From: [REDACTED]
To: [Planning](#)
Subject: Application Ref.6/2022/0922/FULL
Date: 27 May 2022 17:44:38

With reference to the proposed development at No.11 Tolmers Gardens, EN64JE, I have the following comments to make -

21005_PL(20)003

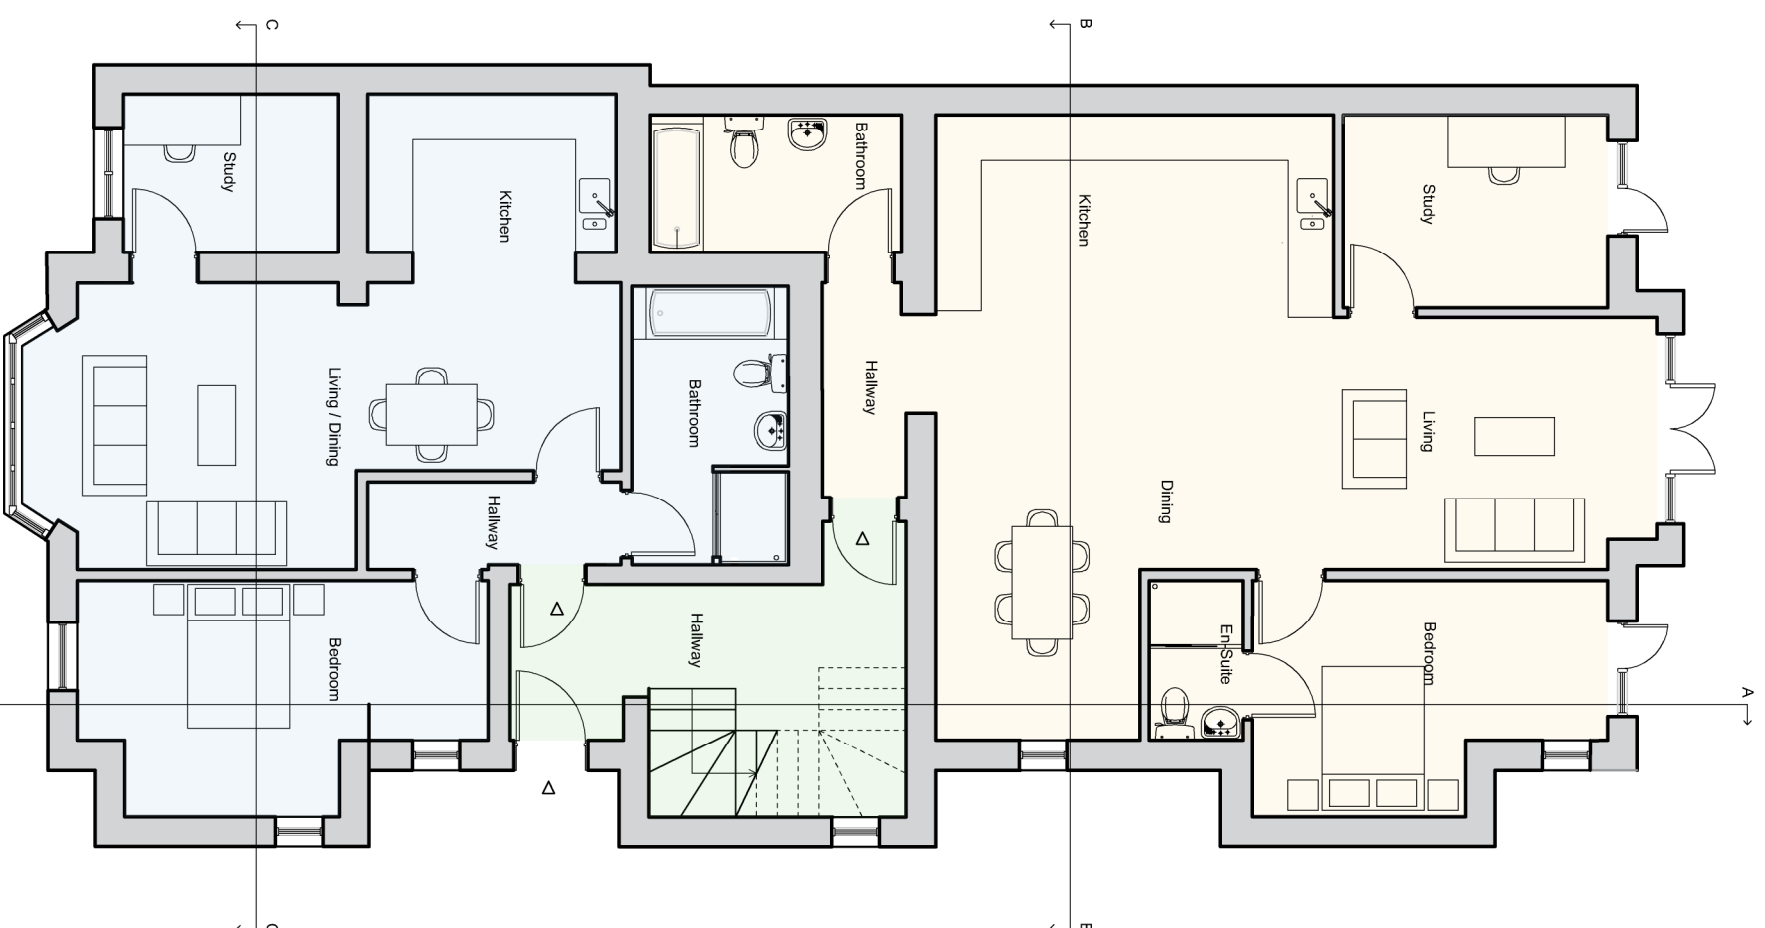
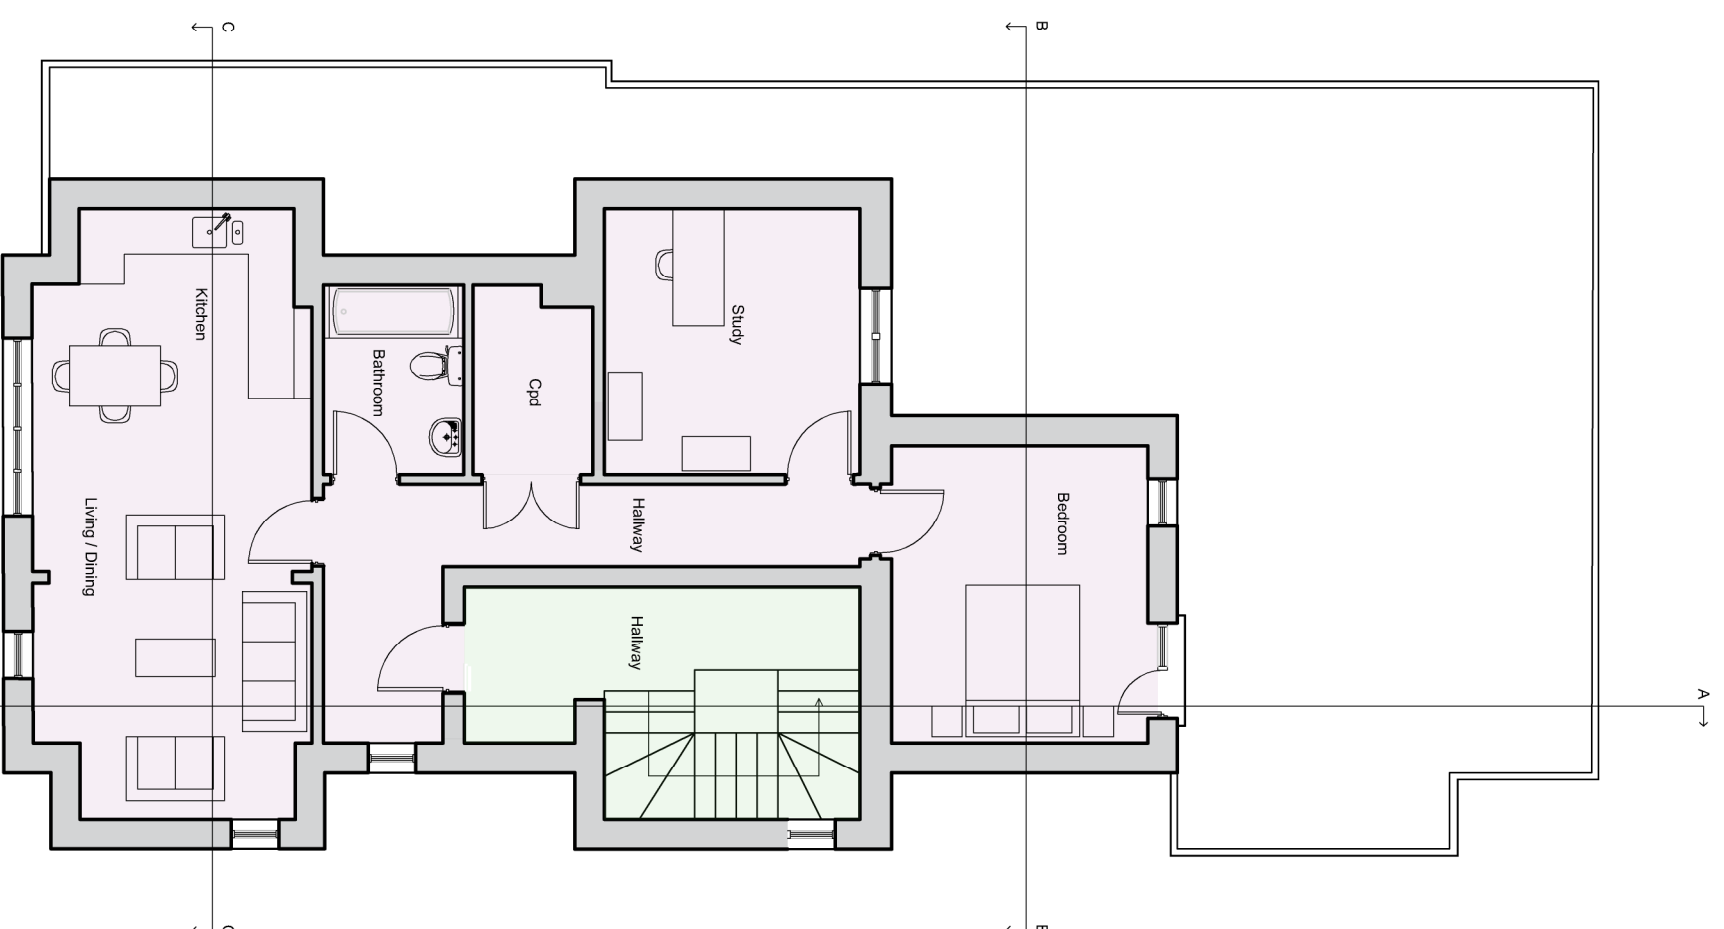
3. The proposal of 4 x 1 bed flats is rather a misnomer as when one looks at the plans they actually include a "study" area, which could be turned into another bedroom. This would be much more in keeping with the proposed size of the flats.

4. The proposed allocation of 4 parking places to the front of the flats is totally inadequate bearing in mind item No.3 above.
5. Where do the rubbish/refuse bins go ?

Elevations as Proposed
West and East

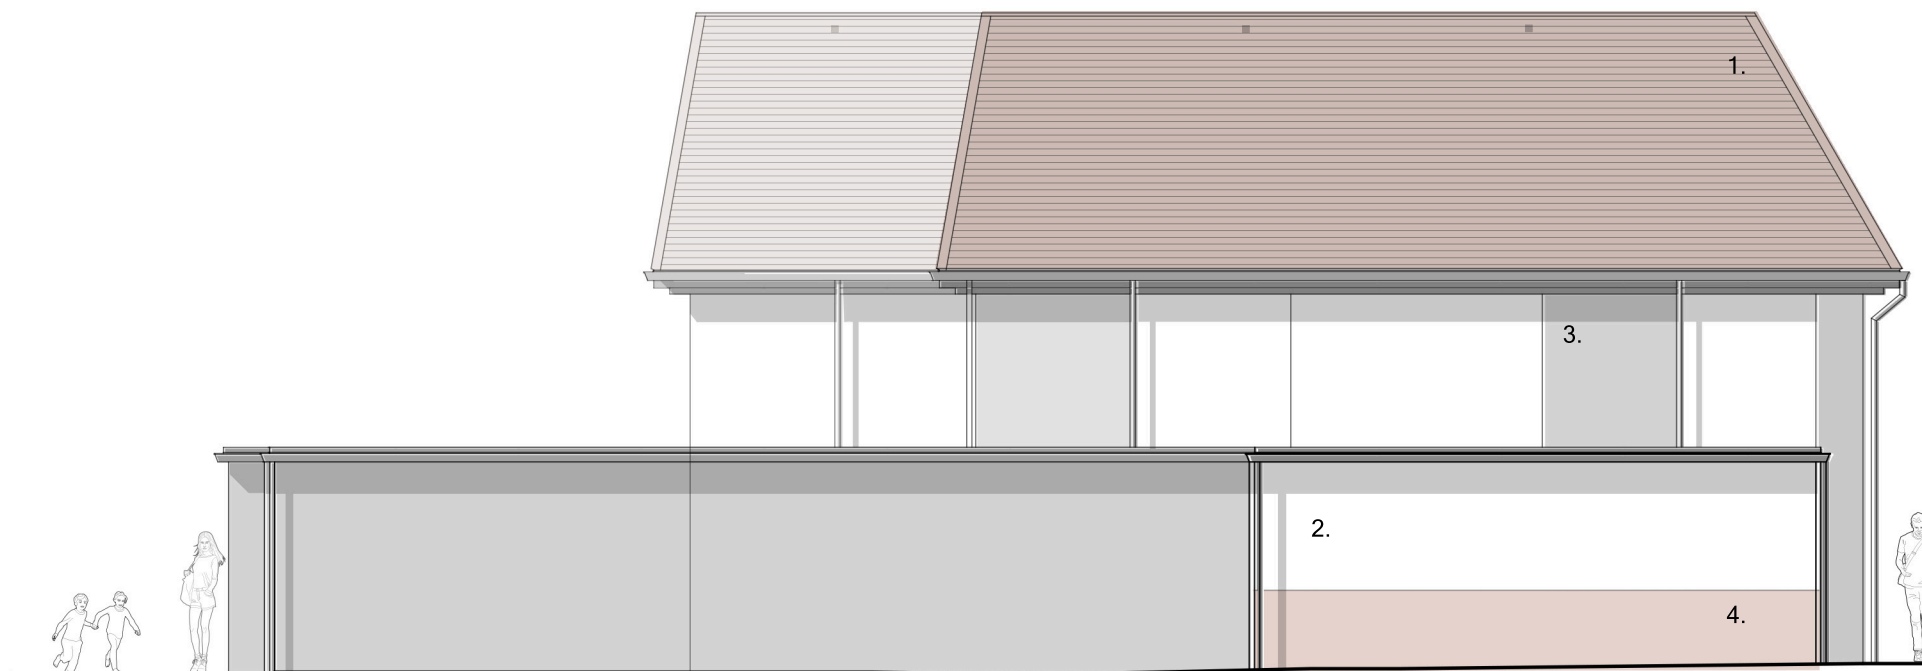
1. The impression is that the bulkiness and pitch of the roof, plus building out to the boundaries, is not in keeping with the street scene.
2. It would seem that when permission was granted for the 8 flats at No.12, the whole site was part of the proposal. It would now seem that a large part of the site of No.12 is being hijacked into the proposal for No.11. which gives the impression that the site on its own is not large enough for the proposed development and therefore they have had to increase this.
